Our Ref: EN010101

Date: 23 December 2020

#### **Application by INRG Solar for an Order Granting Development Consent for the Little Crow Solar Park Project**

#### **Advice following issue of decision to accept the application for examination**

# LITTLE CROW SOLAR PARK - LAND PLAN INCLUDING ORDER LIMITS

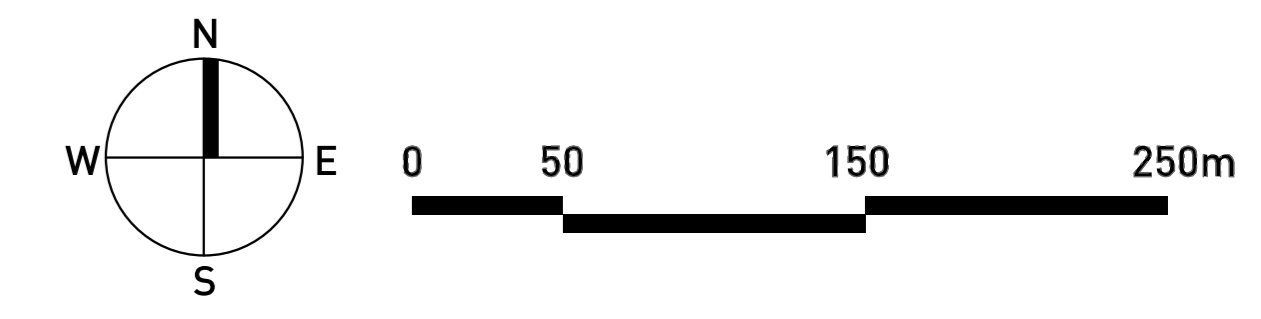
Part 3 (Easements, or other private rights proposed to be interfered with, suspended or extinguished) of the Book of Reference (Doc 3.3) includes landowner information in plots 1/12 and 1/14, however it is stated in Parts 1 and 2: ‘*number not used*’. Those two plots are also not included in the Land Plans.

The Land Plans appended to the BoR also do not include the hatched area in the top righthand side of the boundary that is identified as being ‘*excluded from the Order limits*’ in the other plans included in the application.

Please provide clarification on the above or updated versions of the documents with corrections provided.
